ENG-SF20028-R2-CDs.pdf Markup Summary

Subject: Callout
Page Index: 1
Date: 4/19/2021 4:09:16 PM
Author: dsdrice
Color: ■
Layer:
Space:
Page Label: [1] 1 CV01

**FOUNTAIN GRASS GROVE_EAST PROFILE
STA 1+00.00 TO 4+85.65**

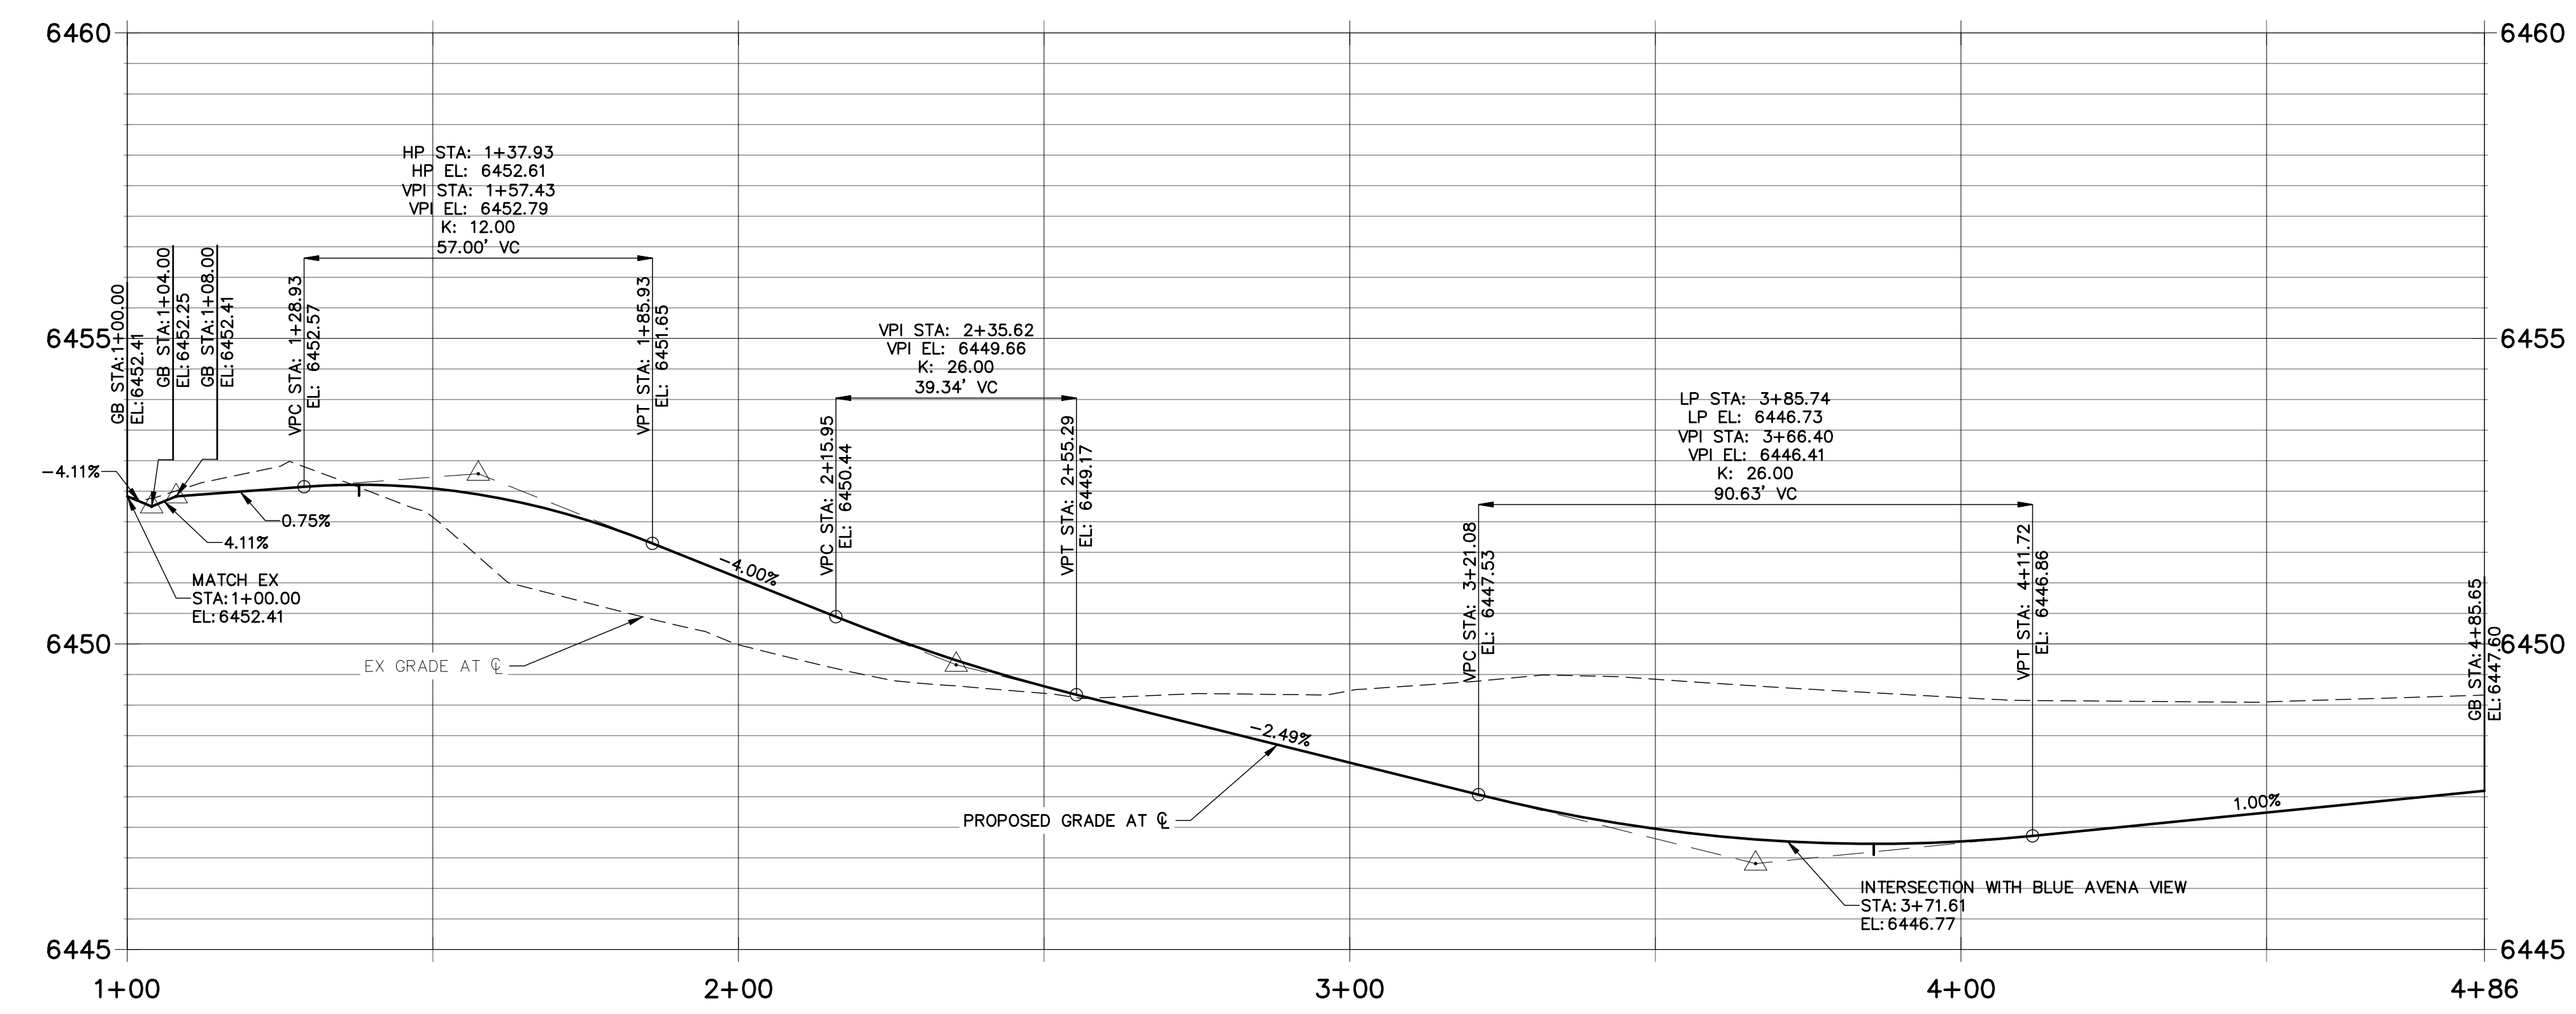
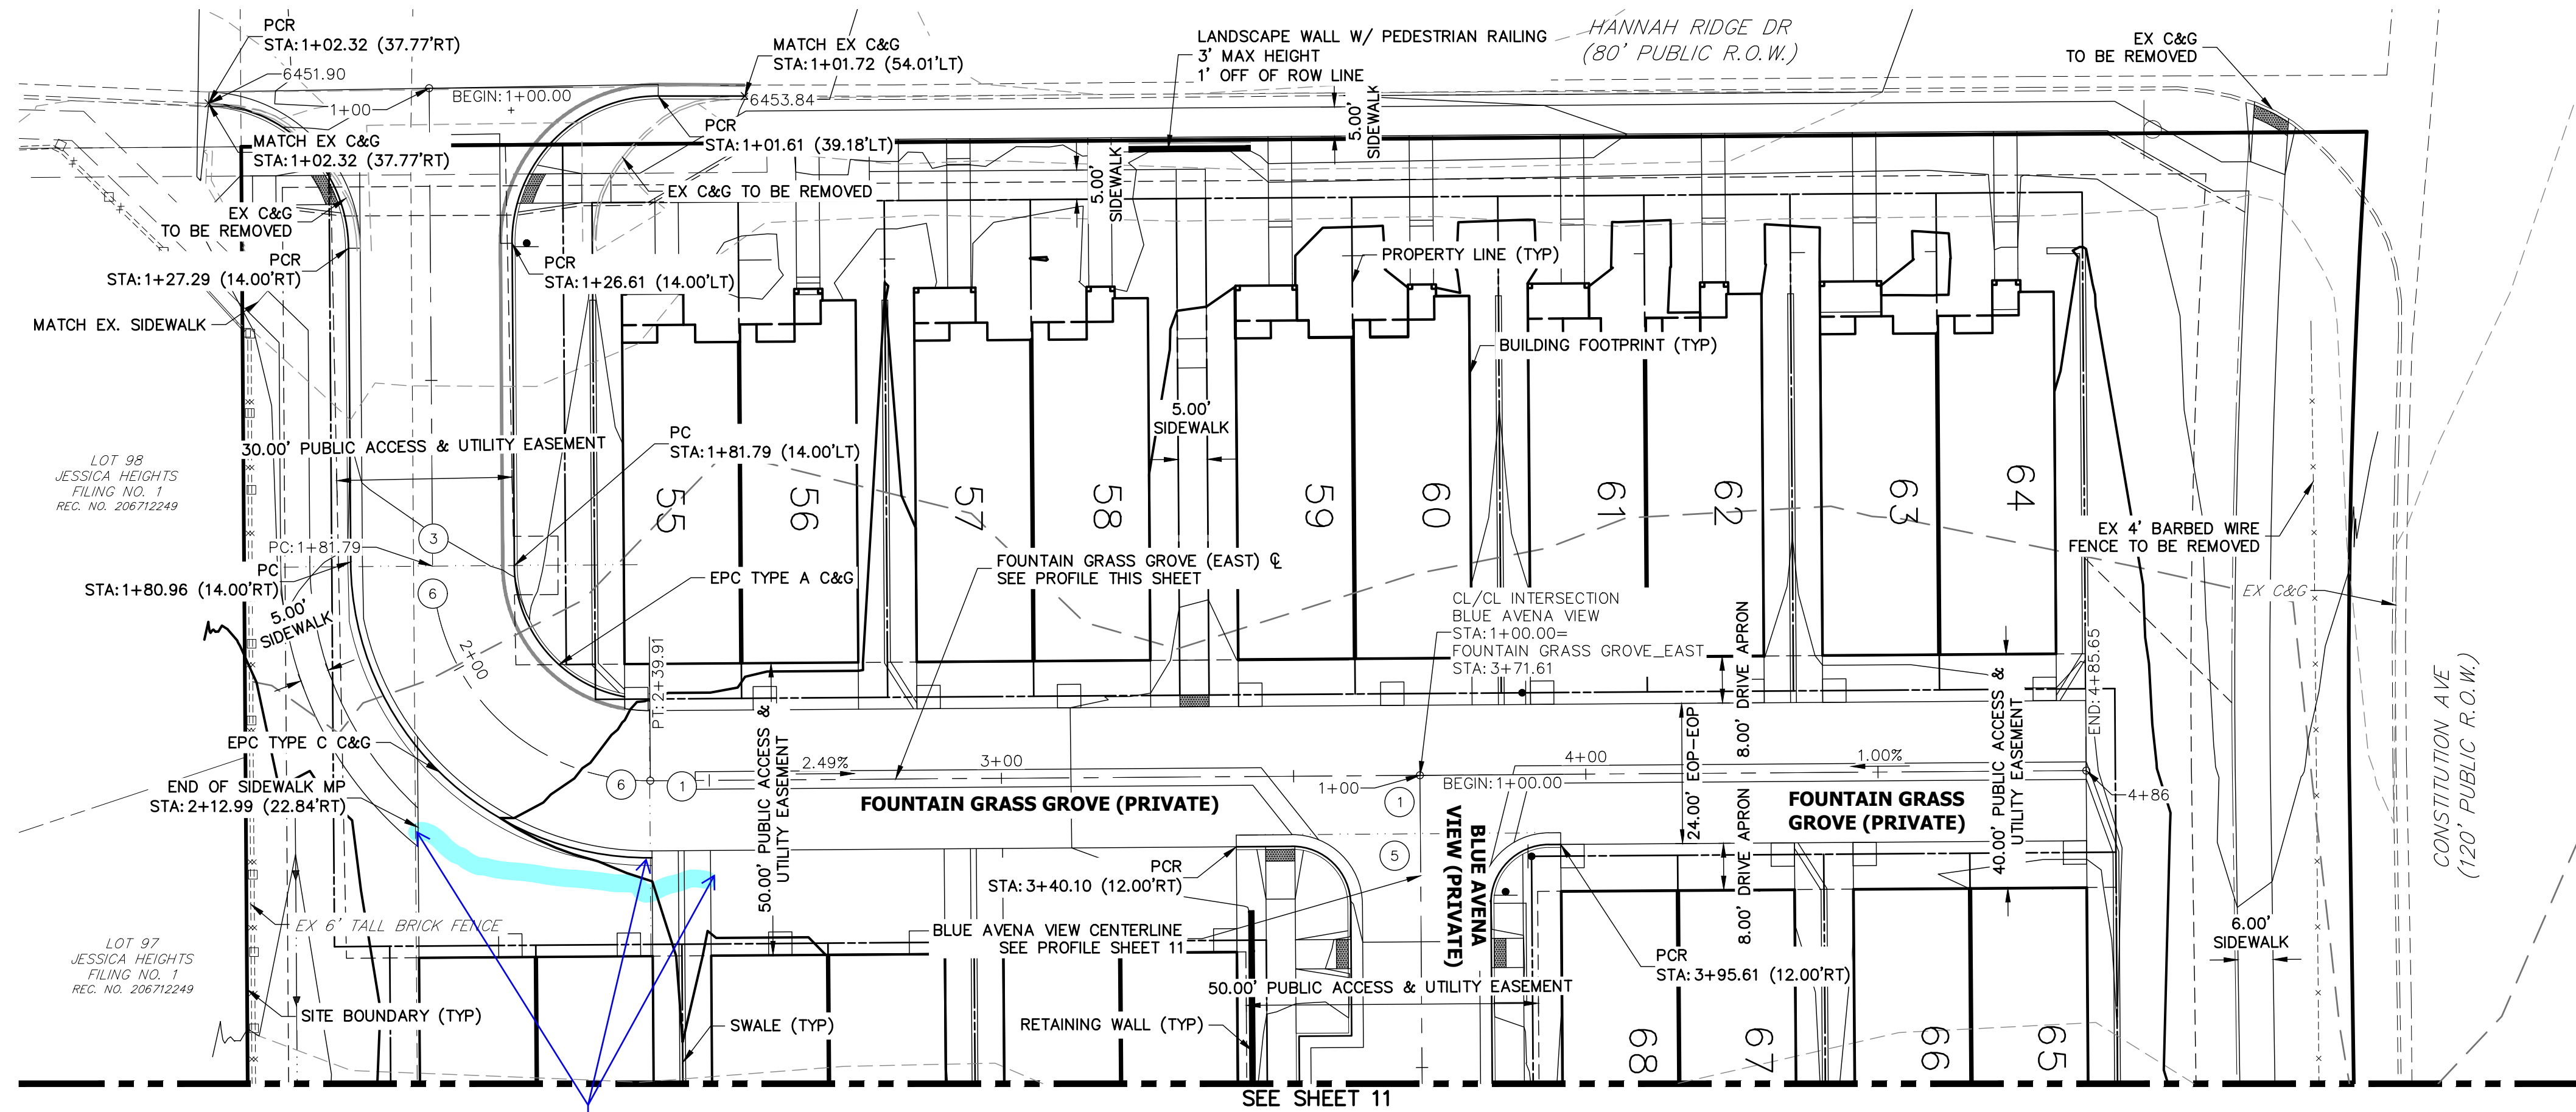
connect sidewalk to driveway or ramp?
